Application No: LU/310/18/PL

Recommendation Report for Planning Permission

LOCATION: 1 Arcade Road
Littlehampton
BN17 5AP

PROPOSAL: Addition of first floor to form self-contained flat, change of use of existing leisure use (D2 Assembly & Leisure) to office use (A2 Financial & Professional Services) at ground floor & external alterations.

DWG. NO / 021018/TP.01

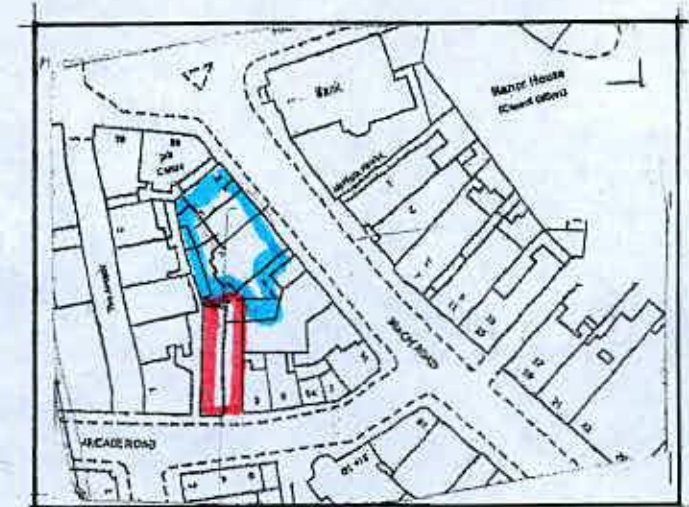
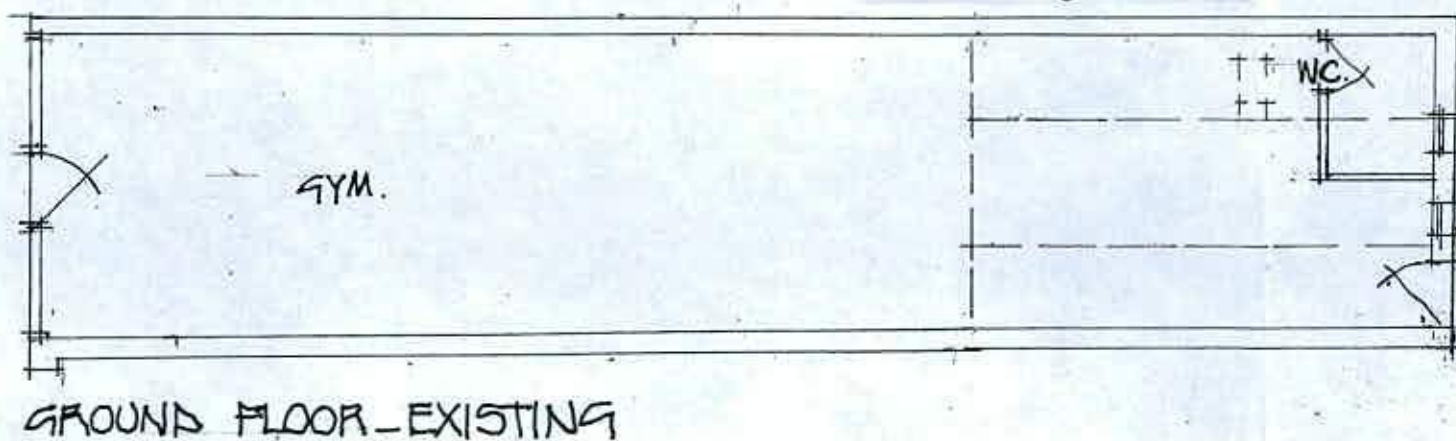
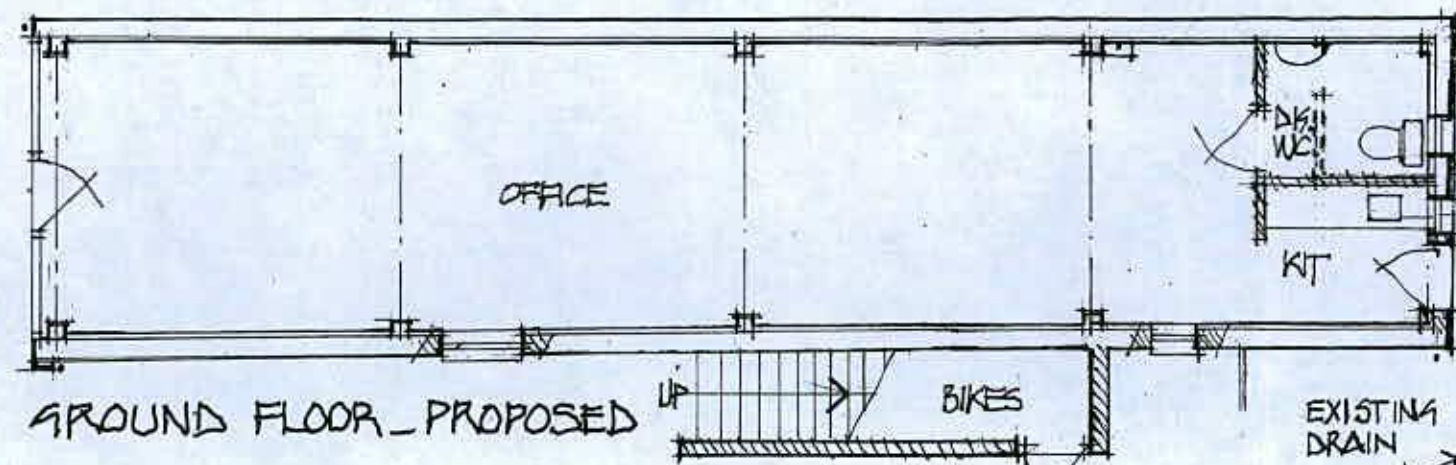
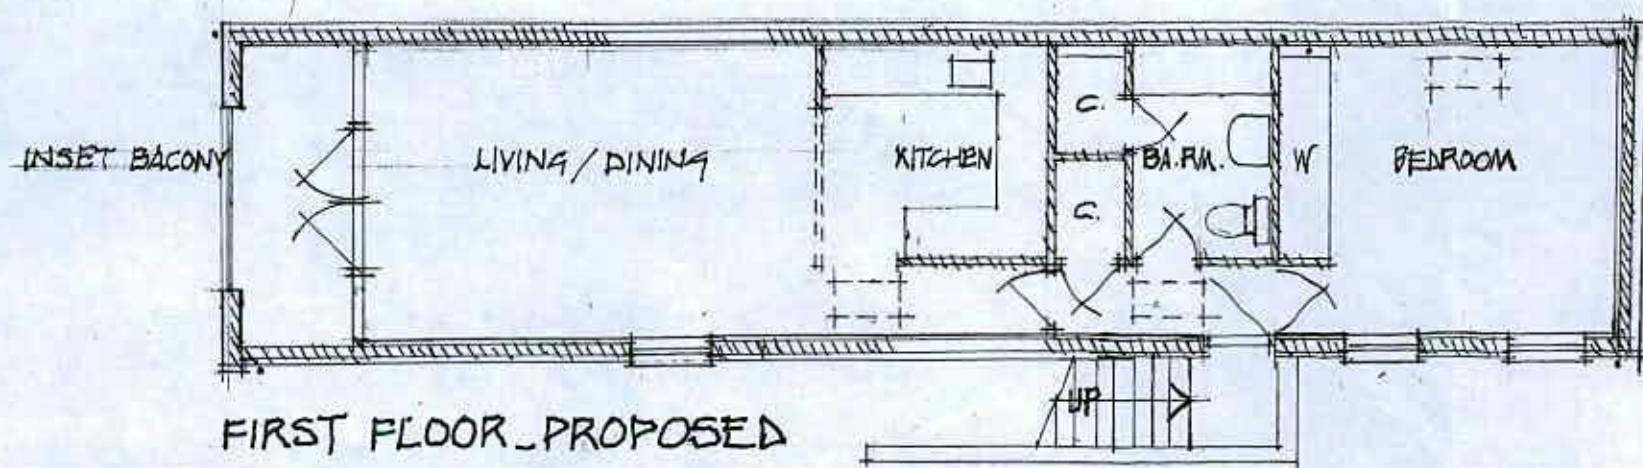
(High Risk). Whilst the FRA does not comply with national guidance the Environment Agency are satisfied, on flooding grounds, with the proposed layout given that habitable rooms will only be located at first floor above 4.94m AOD. The Environment Agency consider this to be an acceptable layout to mitigate the tidal flood risk.

DWG. NO / 021018 / TP.02

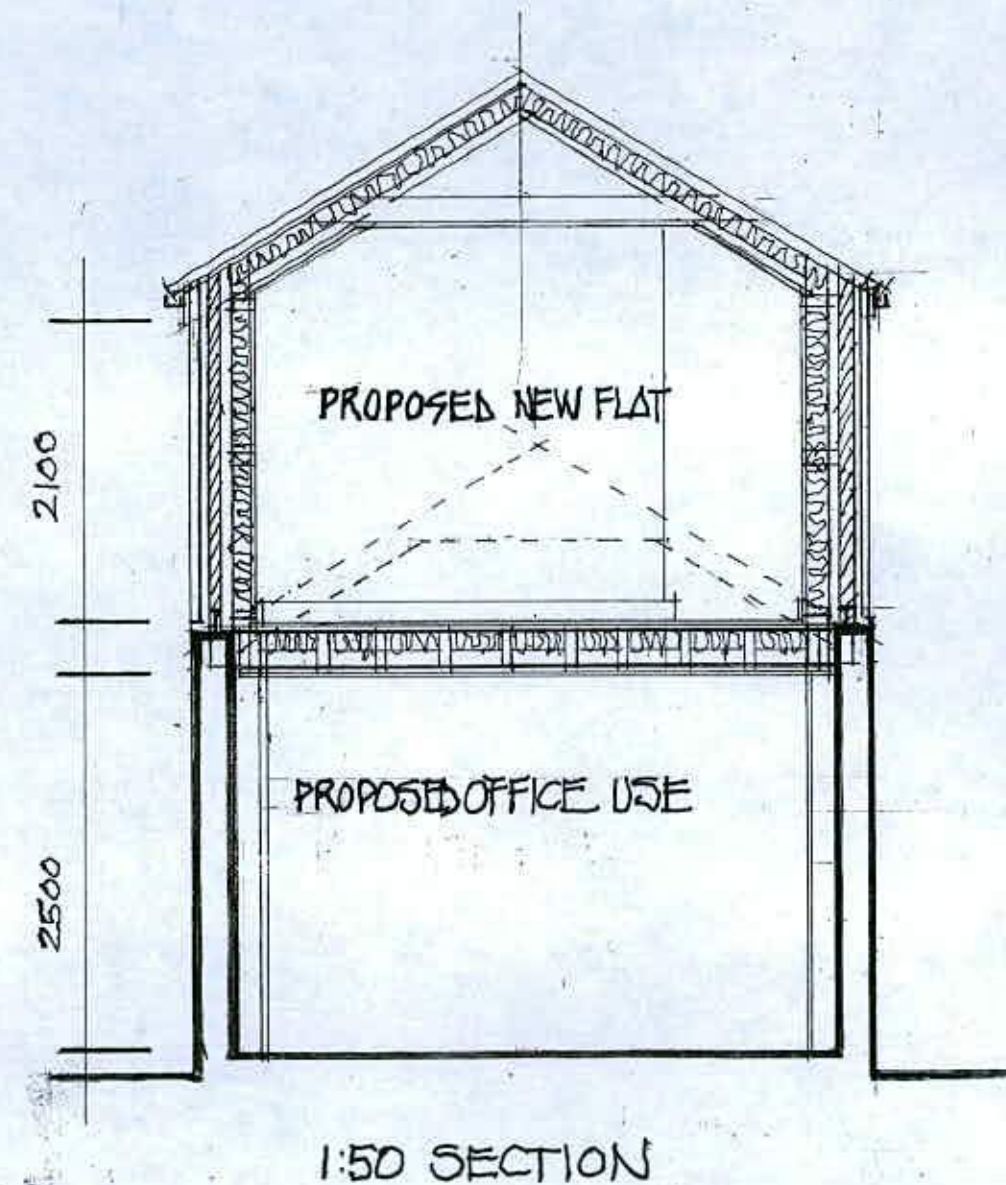
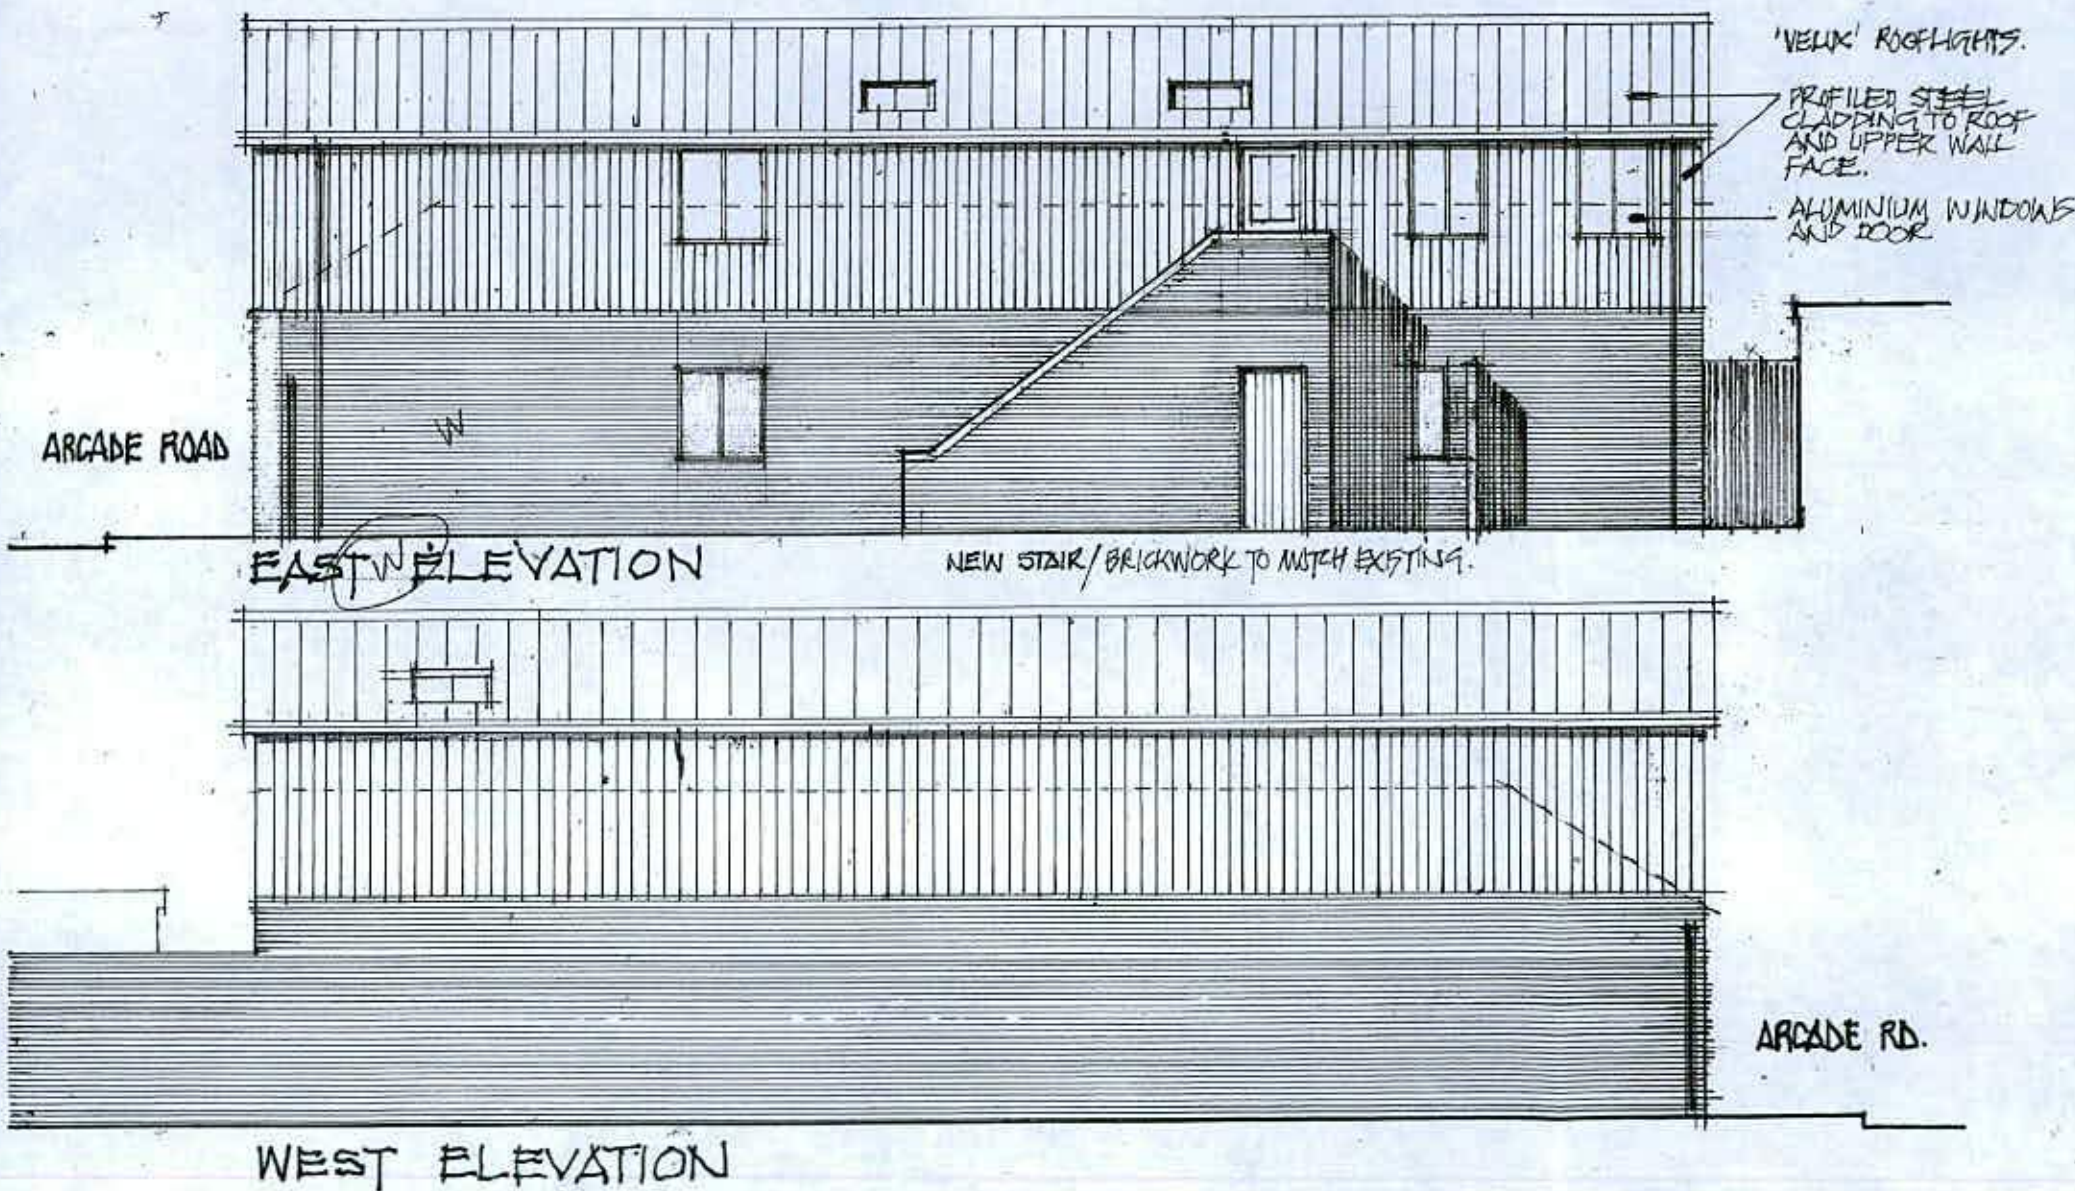
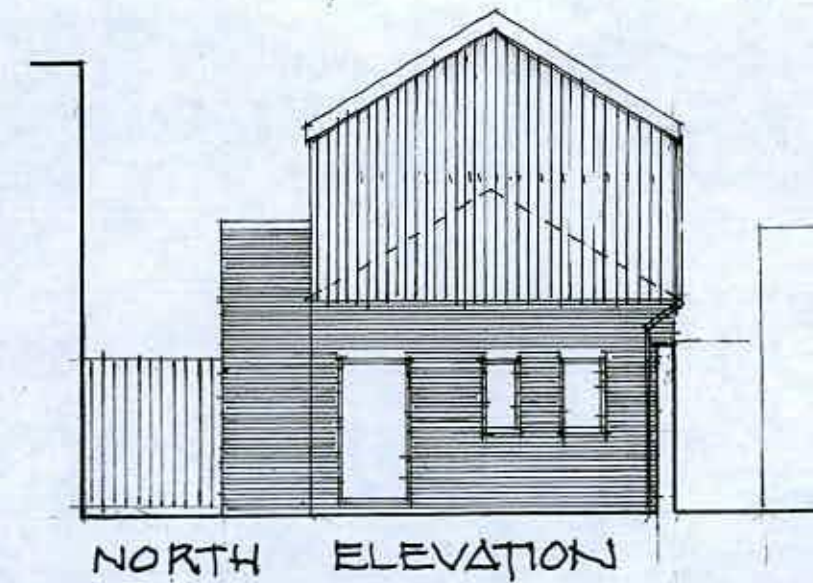
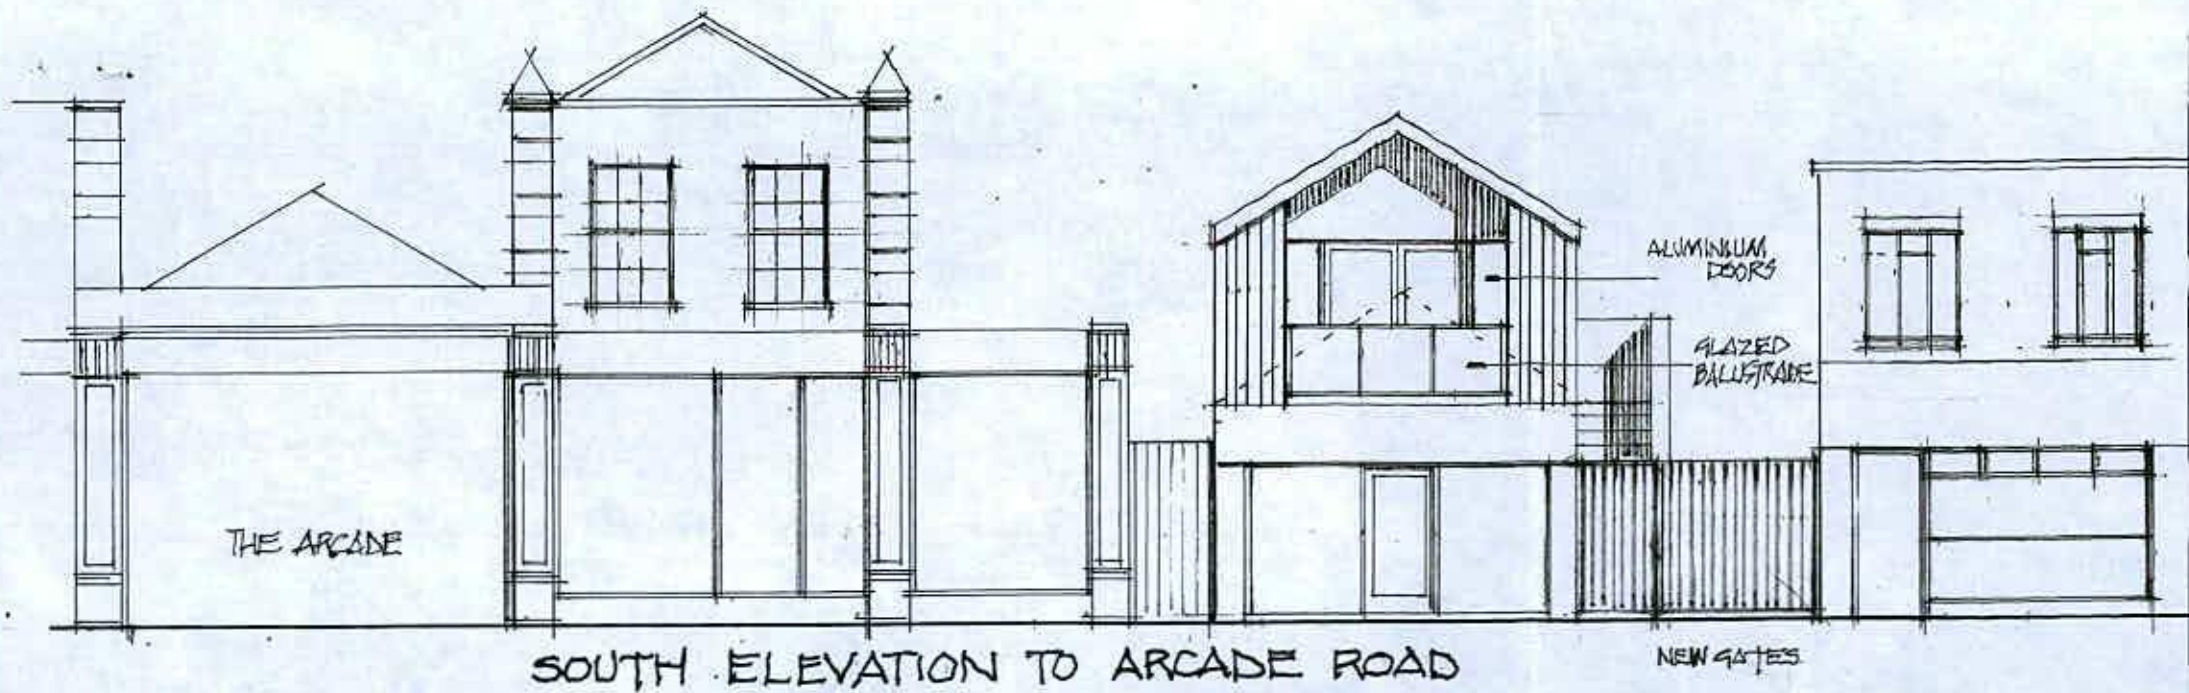
The extension is significant in size and would be visible on the street-scene. An additional floor could

enhance the appearance of the building, but the current proposal does not demonstrate that the material will reflect the character of buildings found in the local area.

The proposed profiled steel cladding to the roof and elevations which are indicated on the elevation plans would detract from the traditional materials used on neighbouring properties and it is therefore proposed to condition these materials to ensure that the development enhances the area and does not detract from the appearance of the street scene nor the setting of the Arcade a Locally Listed Building. The extension would be readily visible given its position on the road frontage but it is in keeping with the height of adjacent development and therefore the scale and character of the area. Together with the conversion of the ground floor it would accord with policies DSP1, DDM1, DDM4 (a) and (e) of the Local Plan and Littlehampton Neighbourhood Plan Policies 1 and 2.

The concerns of the Conservation Officer are being addressed by the deletion of the reference to materials on the elevation plans and the imposition of a materials condition. The provision of the balcony is a positive feature in terms of the external amenity space it provides.

- 3 No development above damp proof course (DPC) level shall take place unless and until a schedule of materials and finishes to be used for external walls (and roofs) of the proposed extension have been submitted to and approved by the Local Planning Authority and the materials so approved shall be used in the construction of the extension.
